## STAFF REPORT

### CRITICAL AREA DETERMINATION

<b>Project No.:</b>	CA019-004
<b>Description:</b>	Request for a critical area determination to average the buffer of a Type 2 watercourse in order to construct a new single-family dwelling. The applicant is proposing to conduct development activity within 478 square feet of the watercourse's buffer, while adding 500 square feet to the buffer elsewhere on the property.
<b>Applicant / Owner:</b>	Michael McFadden (Stuart Silk Architects) / Alexandra Boyle and Charles Lee
<b>Site Address:</b>	4150 Boulevard Place, Mercer Island, WA 98040; Identified by King County Assessor tax parcel number 362350-0174.
<b>Zoning District:</b>	Single Family Residential (R-15)
<b>Staff Contact:</b>	Andrew Leon, Planner
<b>Exhibits:</b>	<ol style="list-style-type: none"><li>1. Development Application, dated March 7, 2019</li><li>2. Development Plan Set, received by the City of Mercer Island on March 7, 2019</li><li>3. Project Narrative, dated March 7, 2019</li><li>4. Critical Areas Report, received by the City of Mercer Island on March 7, 2019</li><li>5. Peer Review Memorandum prepared by Environmental Science Associates, dated May 10, 2019</li><li>6. Bon

1 CRITICAL AREAS DETERMINATION SITE PLAN
1" = 10'-0"

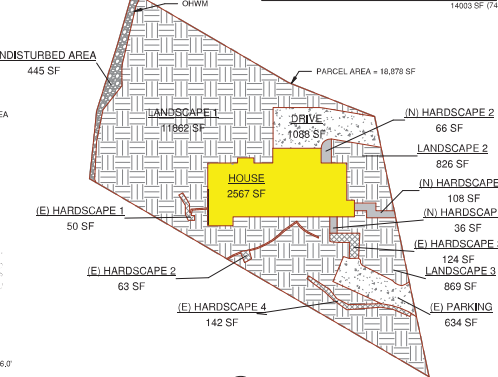
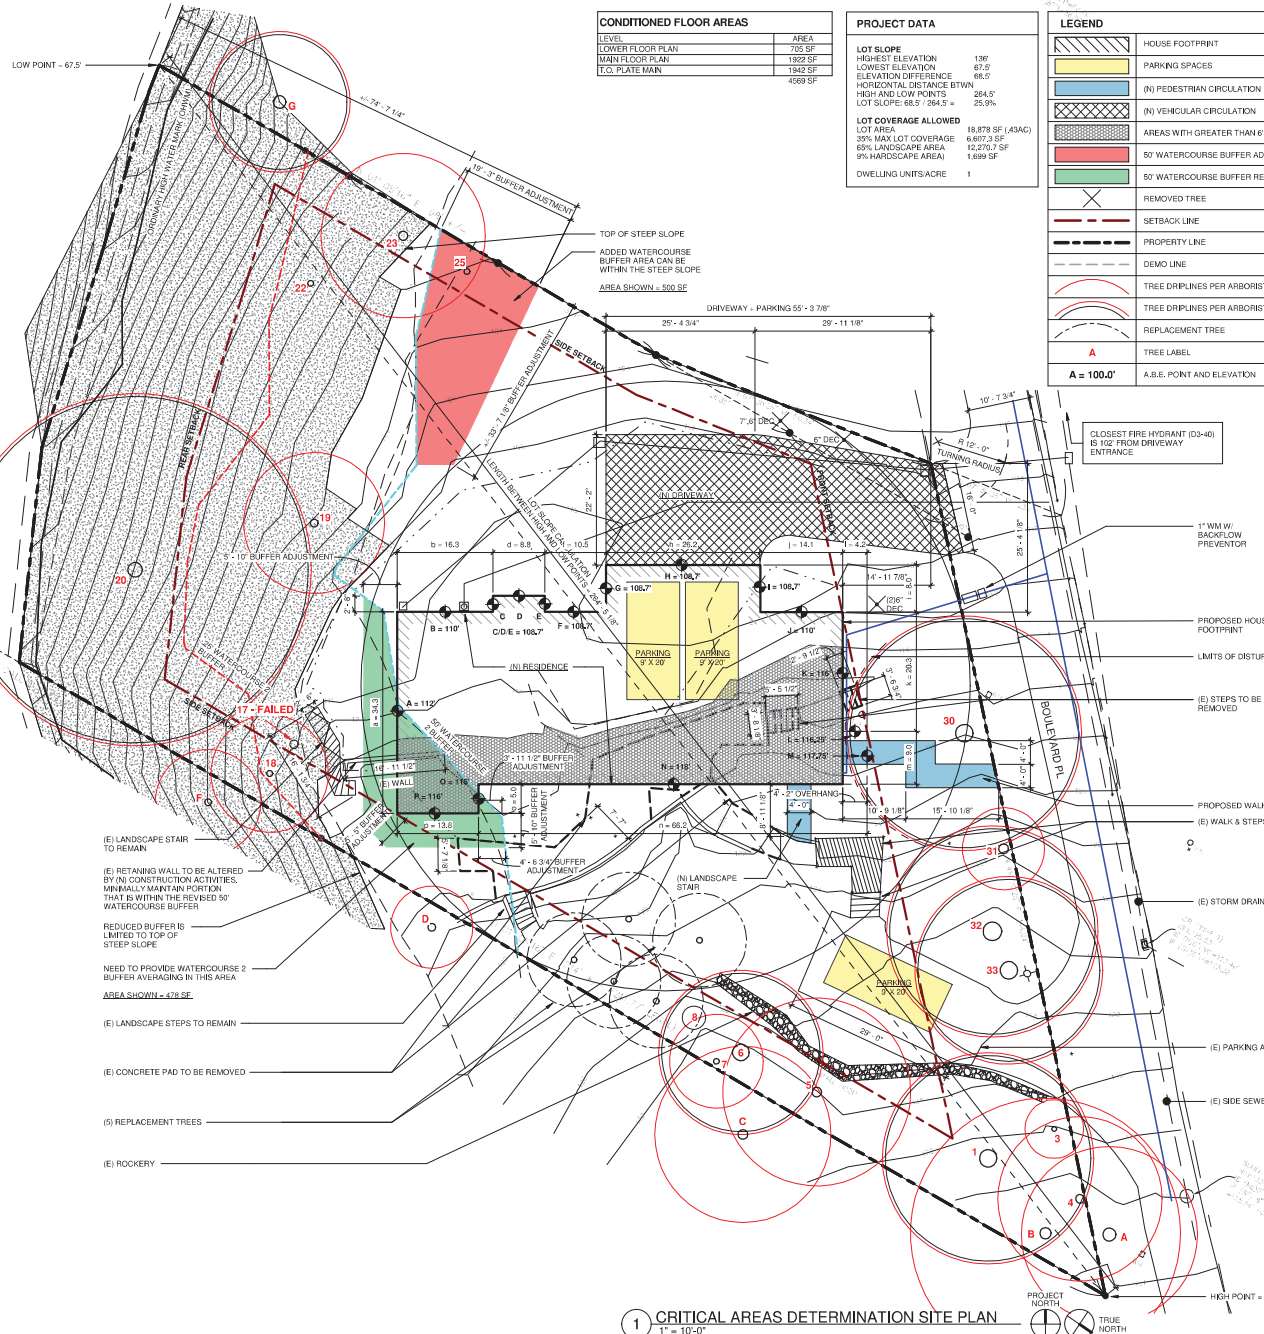
**Staff Analysis:** Sheet CA-1.0 of Exhibit 2 shows that the buffer is being reduced by 478 square feet on the east side of the lot, while 500 square feet is being added to the buffer on the west side of the lot. The total area of the buffer will not be reduced below the area of the buffer if it were not averaged, thereby meeting this criterion.

**Staff Analysis:** Under MICC 19.07.070(B)(1), the standard buffer for a Type 2 watercourse is 50 feet and can be reduced to 25 feet. At its closest point the proposed development will be taking place approximately 32 feet from the watercourse, as shown on Exhibit 2. The standard buffer is not proposed to be reduced below the minimum buffer width at any location. This criterion is met.

**Staff Analysis:** As shown on sheet CA-1.0 of Exhibit 2, the proposed portion of the buffer to be reduced does not contain a steep slope. This criterion is met.
